Your ref: SSD-10425
File no: MC-20-00005

**(SSD10425): Stage 2 – Detailed Development Application - Tallawong Station
Precinct South**

Blacktown City Council's submission to:

LONGITUDINAL SECTION - MC02

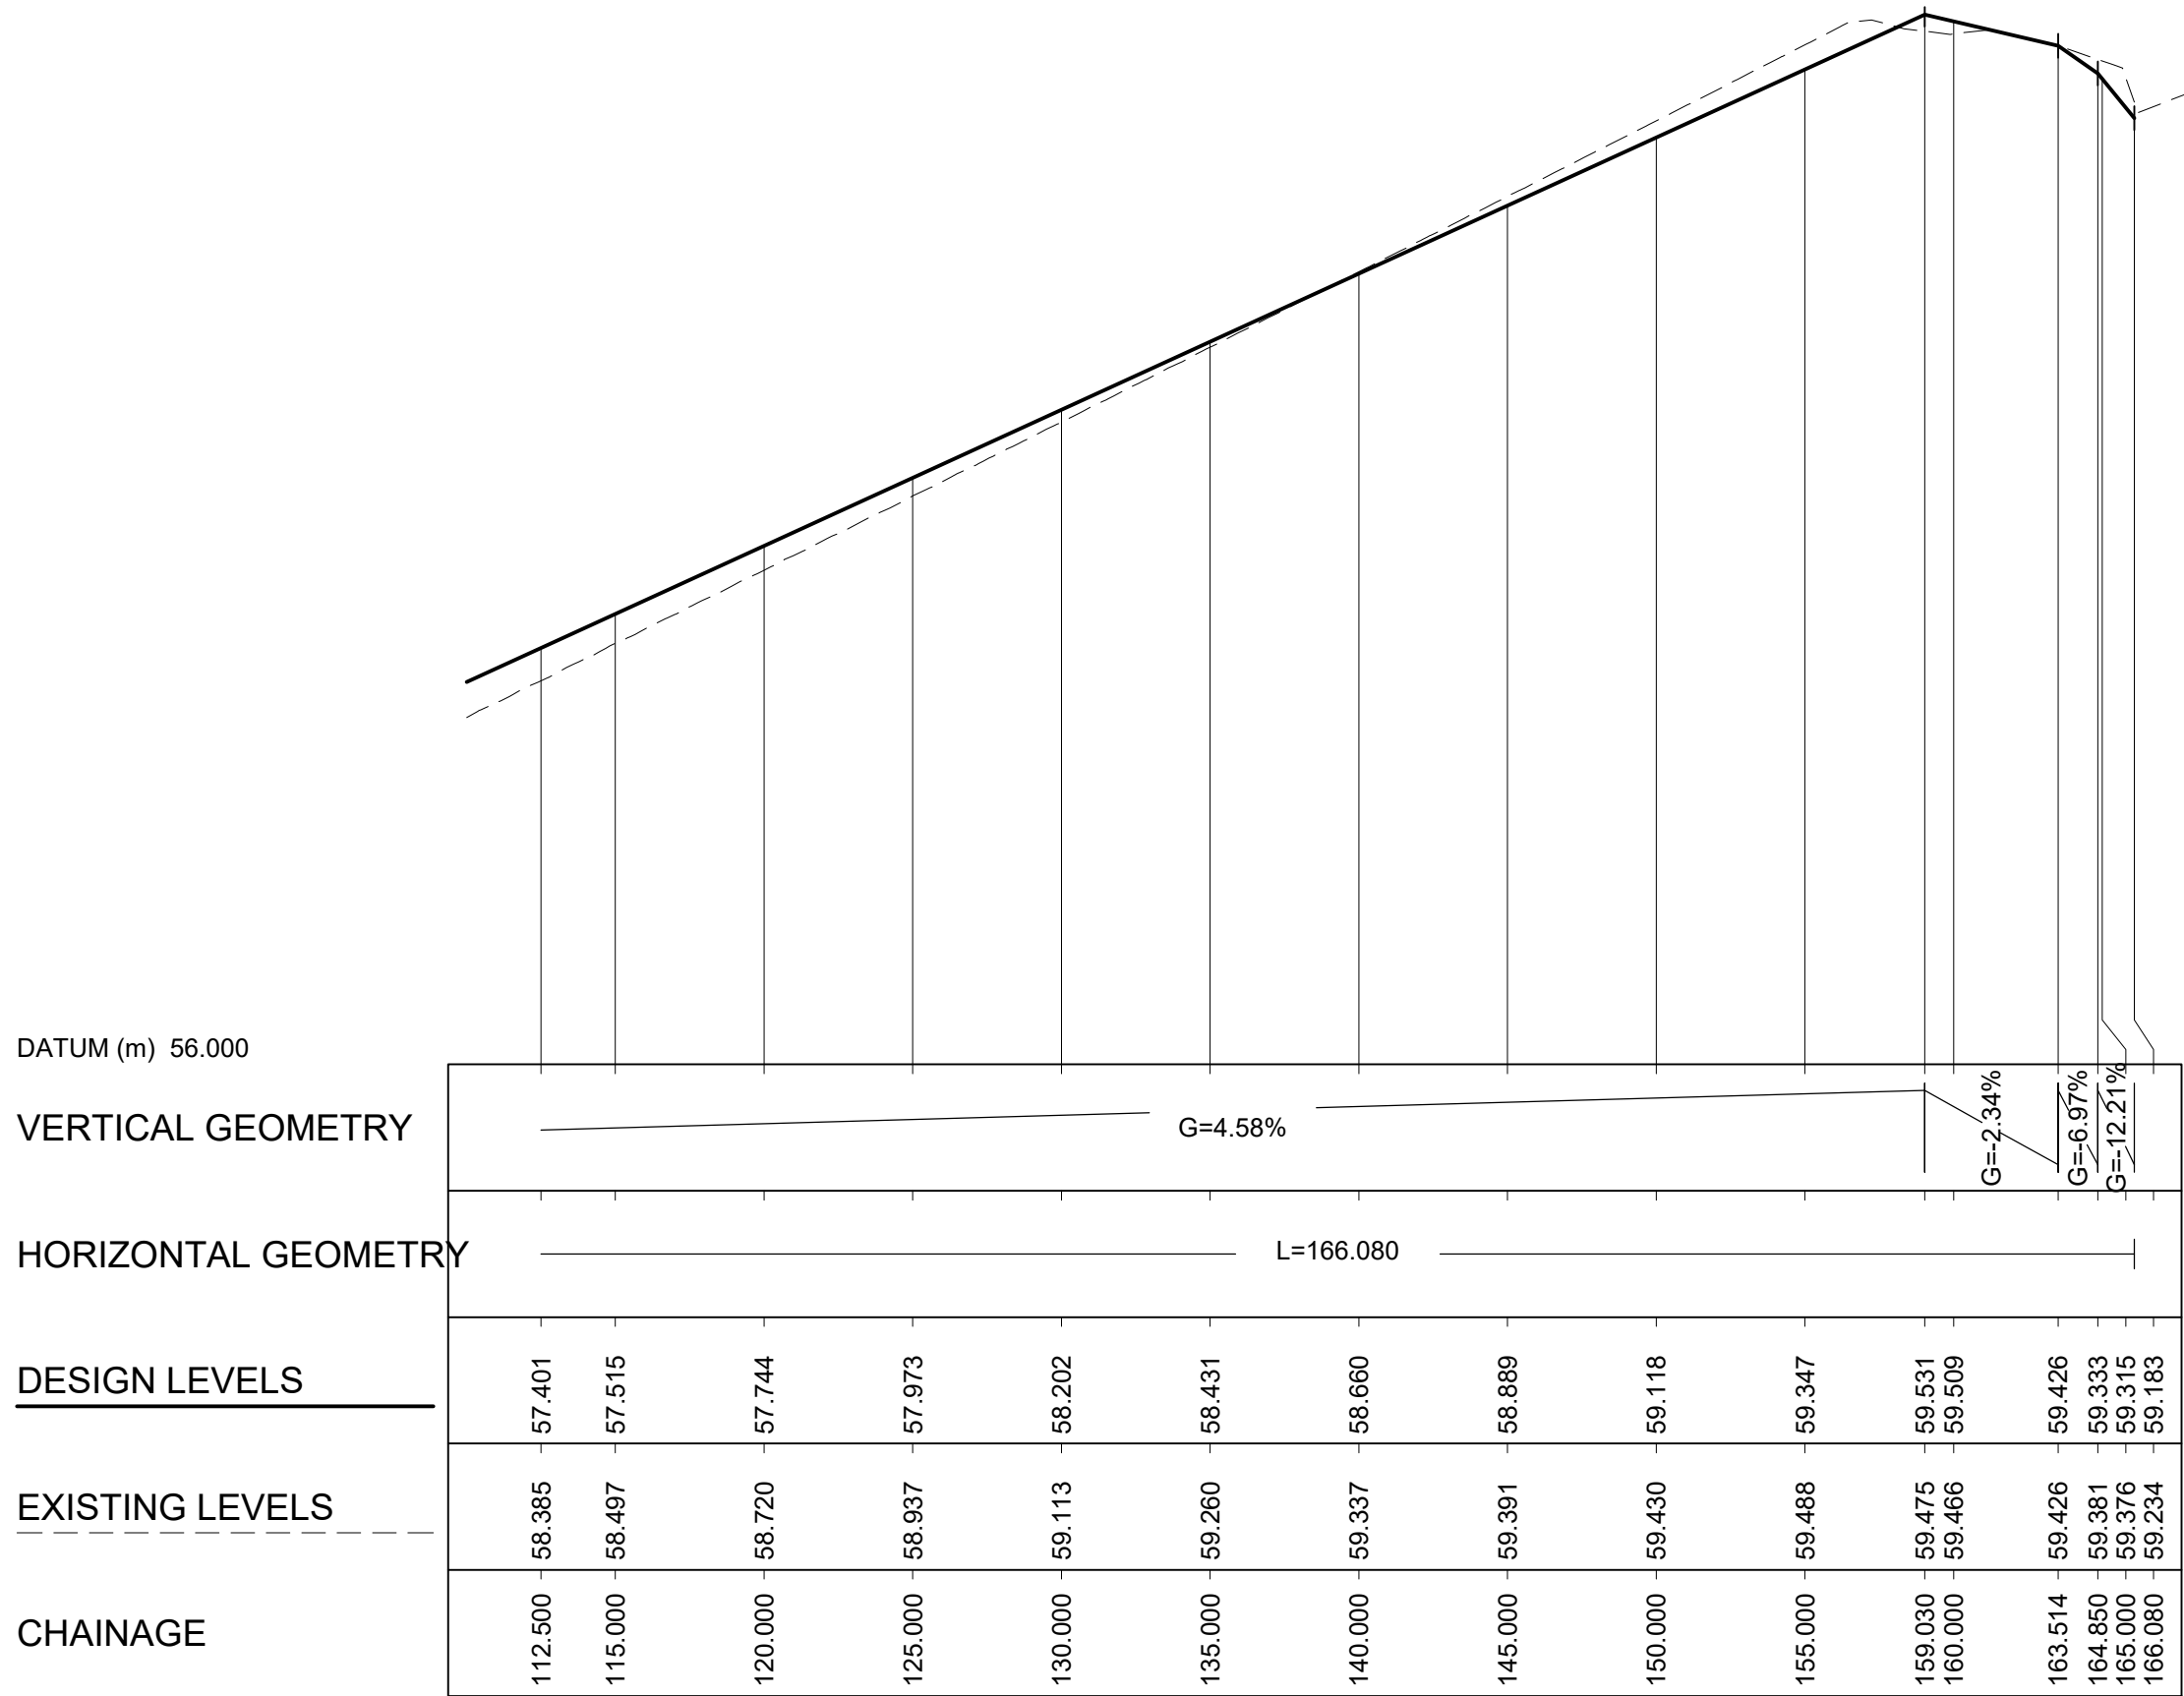
- There appears to be an intentional low point within the internal road MC01/MC02 at chainage approximate 185.00 MC01. The applicant is to demonstrate that the stormwater conveyance of the overland flow path along MC01/MC02 at this point is catered for. The overland flow path is to be reflected on the plan with an associated easement for OLFP.
